# **OXFORDSHIRE COUNTY COUNCIL'S RESPONSE TO CONSULTATION ON THE FOLLOWING DEVELOPMENT PROPOSAL**

**Application No:** 17/01119/REM

**Proposal:** Reserved Matters to 10/01642/OUT - Dorchester Phase 7B, comprising of the provision of nine, two bedroom affordable dwellings with associated landscaping, car parking, infrastructure and external works.

## **Transport**

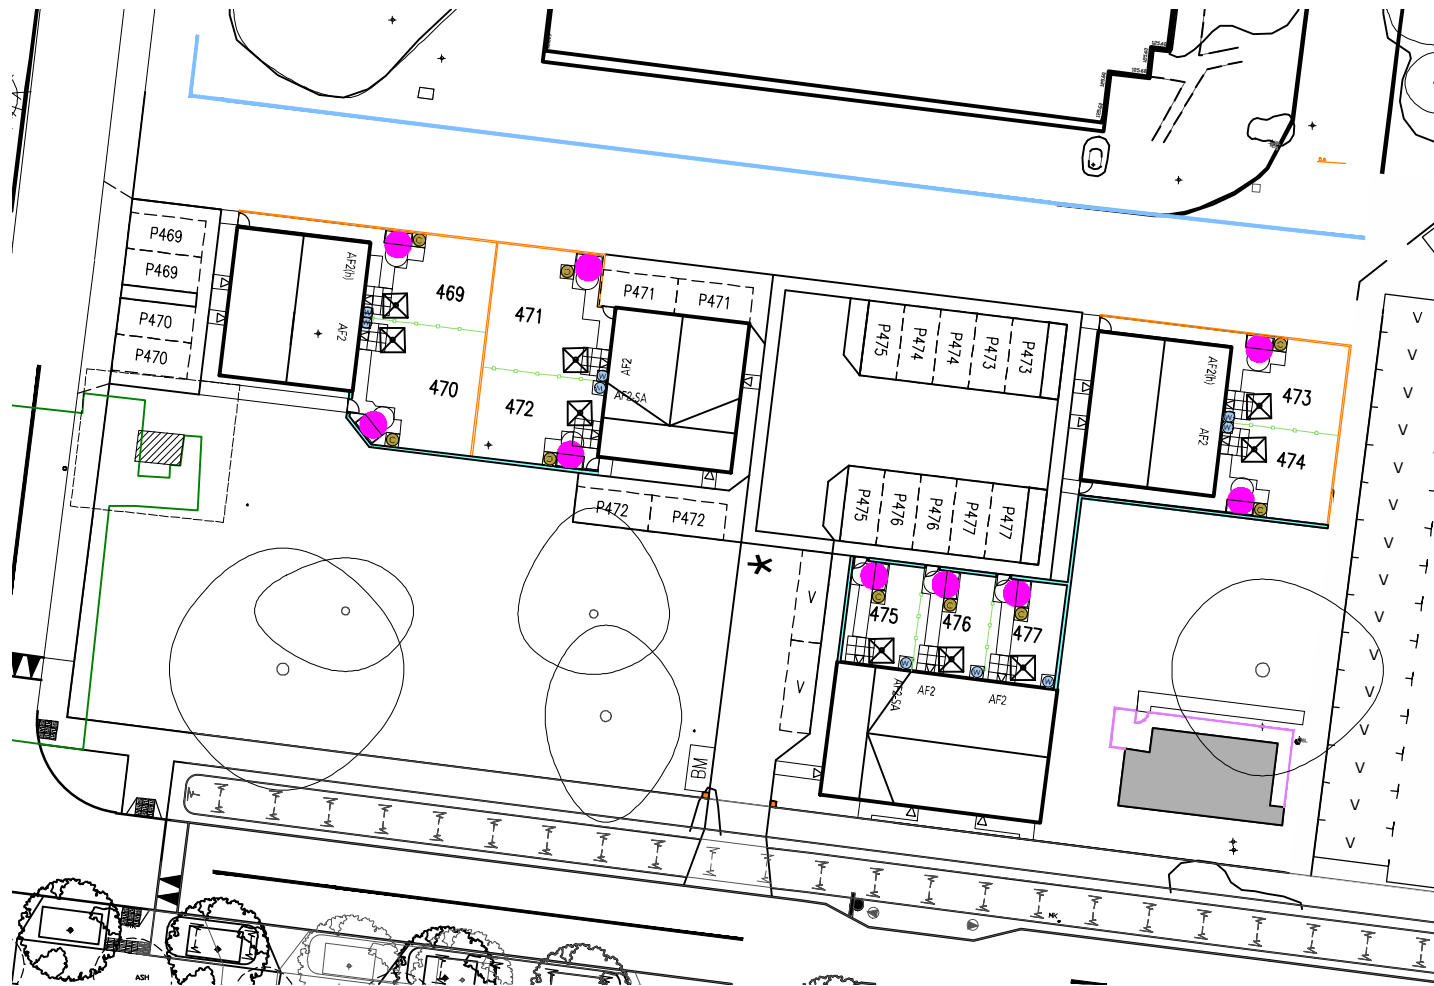
It also appears that the refuse from the site will be collected from a Bin Collection Point near the bell-mouth of the access on the western side of the road. Therefore, a refuse vehicle will not need to enter and turn in the site. Therefore, I have no comments to make regarding this issue.

DRAWING TITLE: ADOPTION PLAN
DRAWING NO.: 0521-PH7B-107

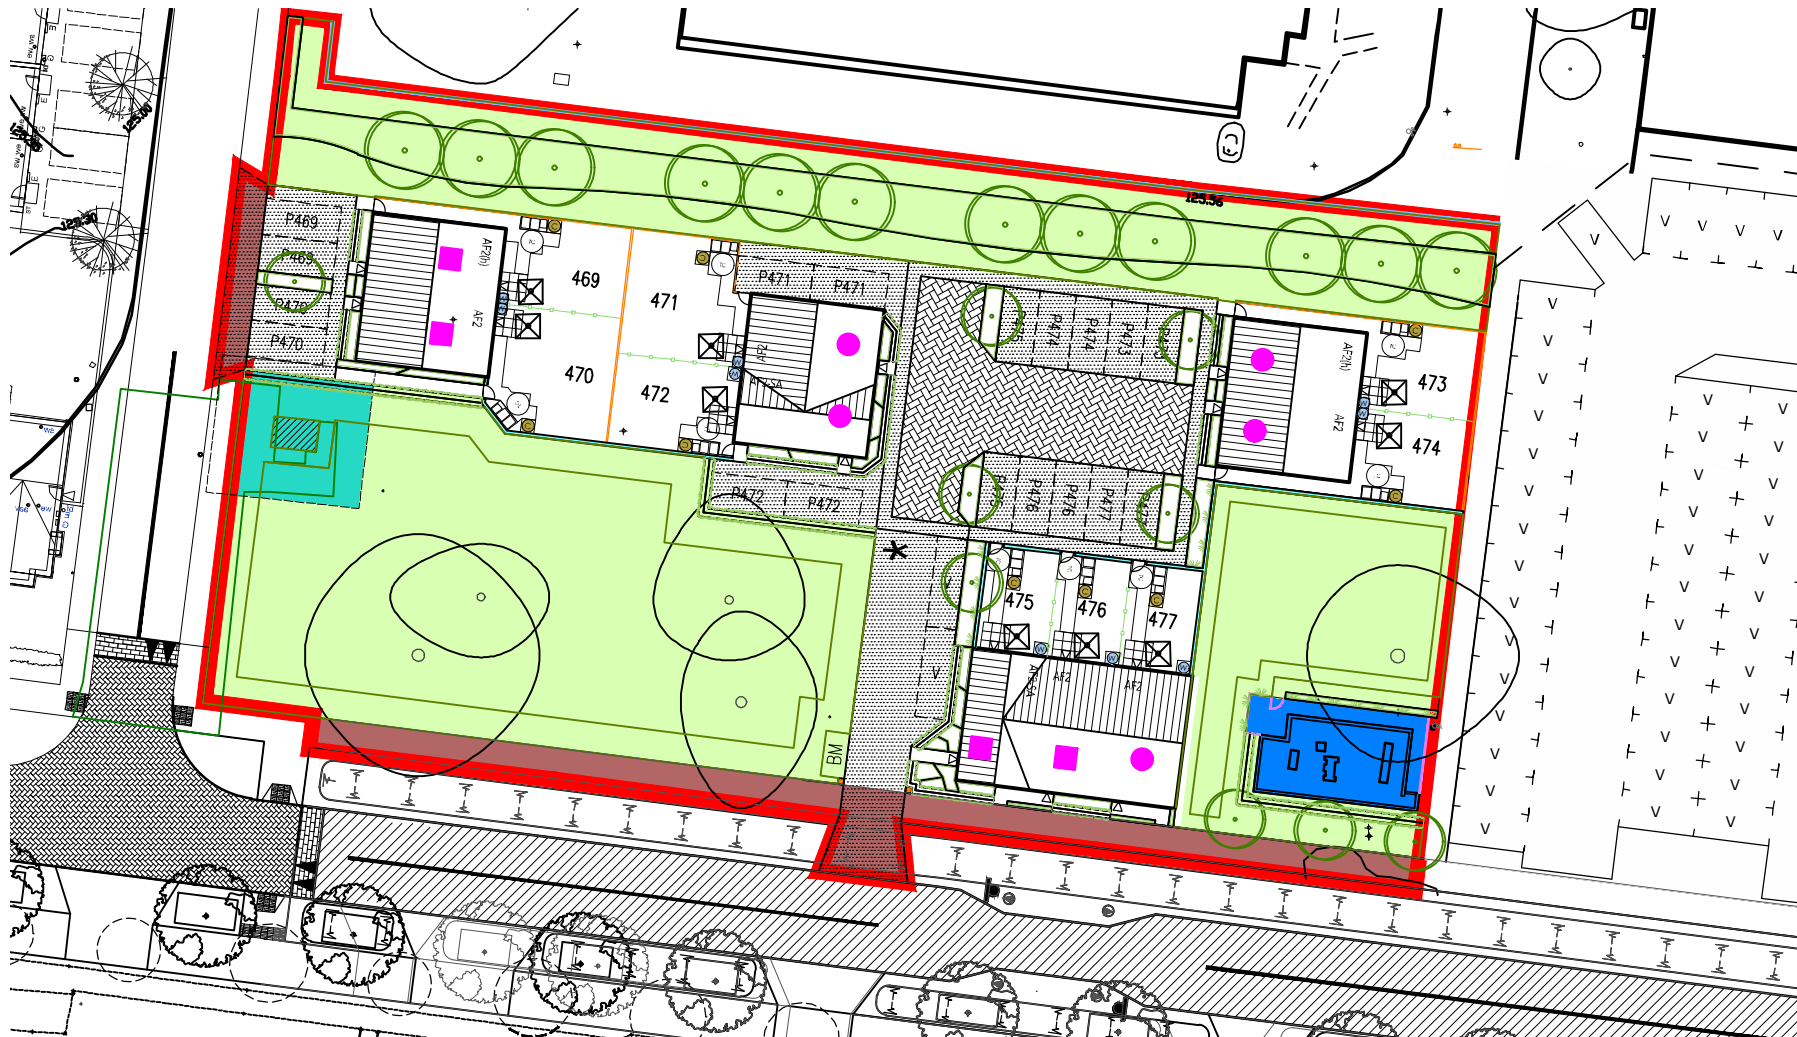
- The shared space access road needs to have total width of 6m.

Although the access road, at the point at which it passes the two on-street visitor parking spaces appears to be a road that the applicant does not intend to offer for adoption as public highway, it should be widened so as to maintain a total width of 6m exclusive of the on-street parking bays. This will allow for a safe area for pedestrians to use the road and will also allow two vehicles to pass each other safely. This is in accordance with the Roads Hierarchy in Paragraph 5.2 of Oxfordshire County Council's Residential Roads Design Guide, which can be accessed at: <https://www.oxfordshire.gov.uk/cms/content/transport-development-control-tdc>.

It is difficult to tell from the Heyford Design Code whether the applicant intends for the access road into this development and the bell-mouth at the point at which it meets Camp Road as this phase of the development is located in a different place to the one it was allocated in the Design Code for the Upper Heyford development. The two visitor parking bays on the eastern side of the access road reduce the useable road width to 4m. This is not sufficient to allow two vehicles to pass each other safely and to allow pedestrians and vehicles to share the space safely. The access road should be widened to 6m to allow two vehicles to pass each other safely and to allow pedestrians to share the space (see the Informatives Section).

Prior to the commencement of development, full details of the access road, together with the two proposed on-street parking bays within the development shall be submitted to and approved in writing by the Local Planning Authority. Thereafter, construction shall only commence in accordance with the approved details.
